Development Facilitation Team (DFT) – Review Comments

Project No: PR-2019-003221 Date: 04/10/2024 Agenda Item: #5 Zone Atlas Page: D-17

**Request: INTERIOR LOT LINE ELIMINATION BETWEEN TWO EXISTING LOTS TO
CREATE ONE NEW LOT, GRANT PUE ALONG WASHINGTON ST NE, DEDICATE
ADDITIONAL RIGHT-OF-WAY TO HAWKINS ST NE RIGHT-OF-WAY**

Project Name: 4015 Hawkins St NE

**Plat for
 Lot 7-A
 Interstate Industrial Tract, Unit IV
 Being Comprised of
 Lots 7 and 8
 Interstate Industrial Tract, Unit IV
 City of Albuquerque
 Bernalillo County, New Mexico
 January 2024**

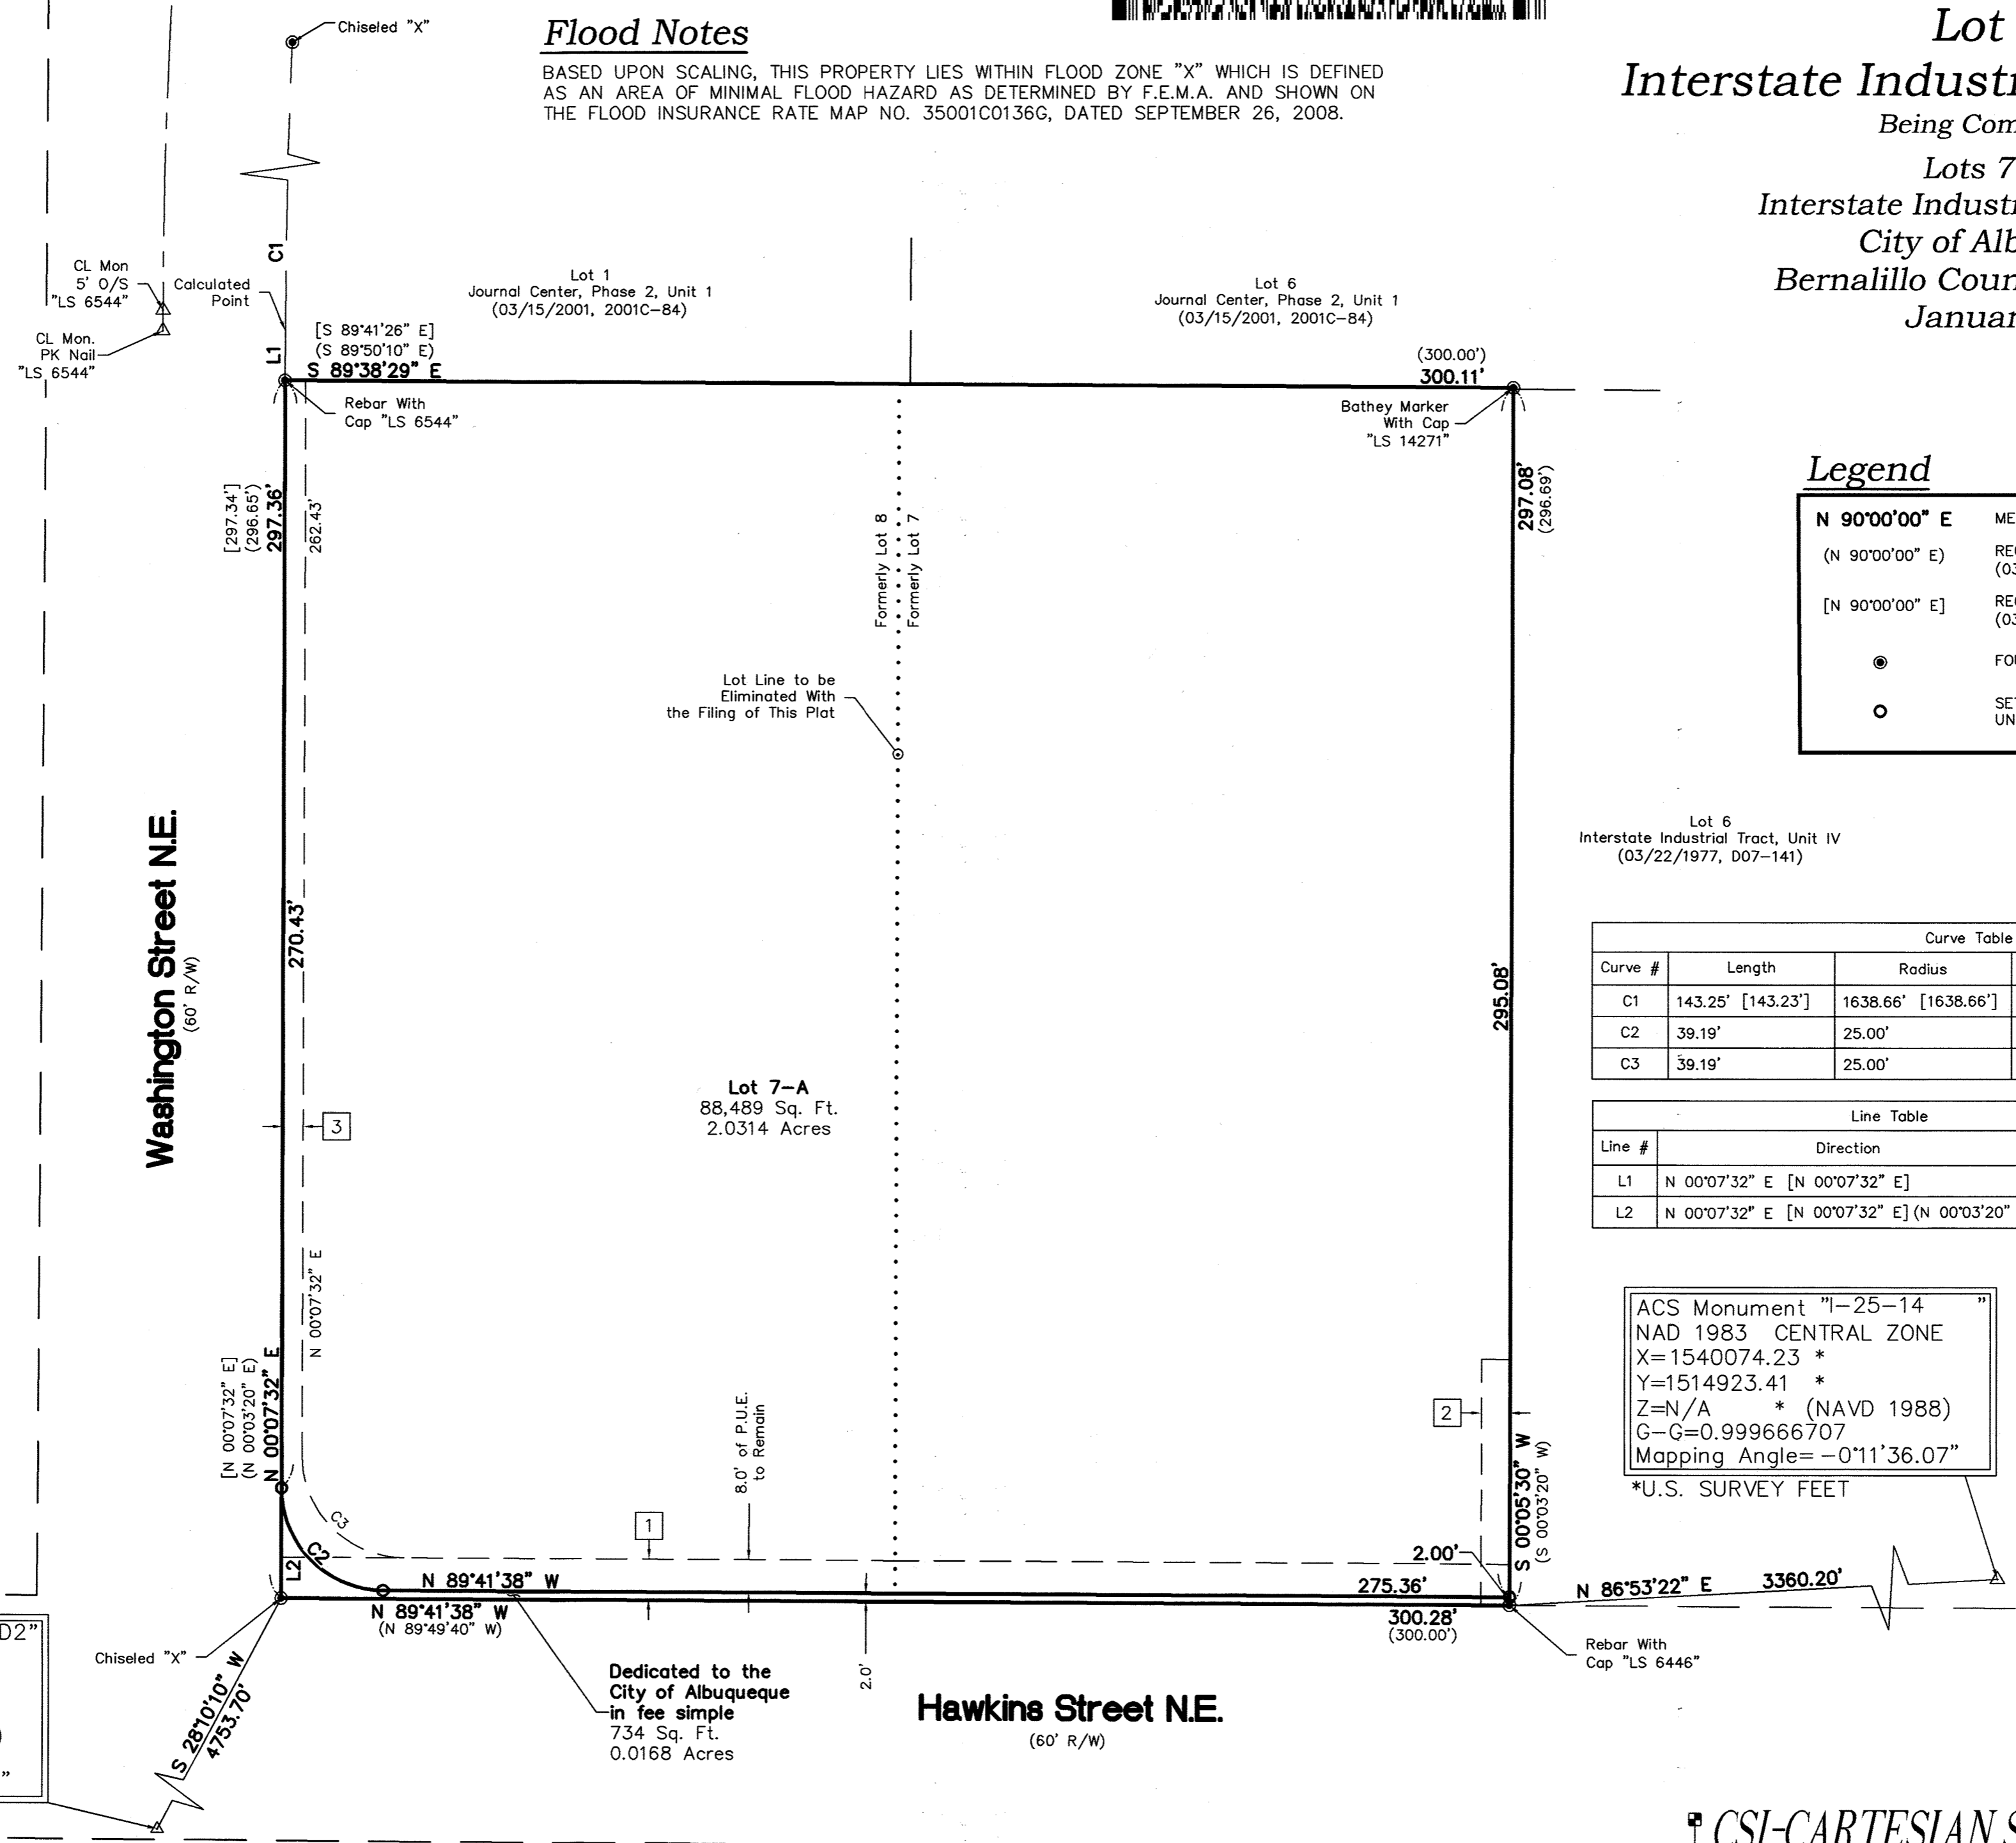
1. You mentioned the 6' sidewalk for Hawkins being on an infrastructure list but there is no infrastructure list included with your application.
2. For future development an approved TCL will be required prior to site plan or building permit. Also, a Traffic Scoping Form will need to be submitted to determine if a TIS will be required.

- Demonstrate compliance with section 7 of the DPM Table 7.2.29 and Required Improvements section from 5-4(N) of the IDO in regards to the sidewalk width requirements and the accompanying landscape buffer.

Provide measurement for the existing ROW and distance from curb to property line along street frontage.

- Hawkins Street is considered a Major Collector Street and requires a 6-foot side walk and 5-6-foot landscape buffer. Please clarify regarding the landscape buffer size. Staff notes that the application submittal includes a response to Transportation comments from the January 8, 2020 Sketch Plat, noting that an Infrastructure List (IL) will be provided to include a 6-foot wide sidewalk along Hawkins. However, an IL was not included with the submittal.

- The application number must be added to the Plat.
- Per 6-6(K)(2)(k), The date of the DHO approval shall be recorded on the Final Plat, and verification of compliance with conditions of approval shall be dated and verified by the signatures of the required commenting agencies pursuant to Subsection 14-16-6-4(J)(2).
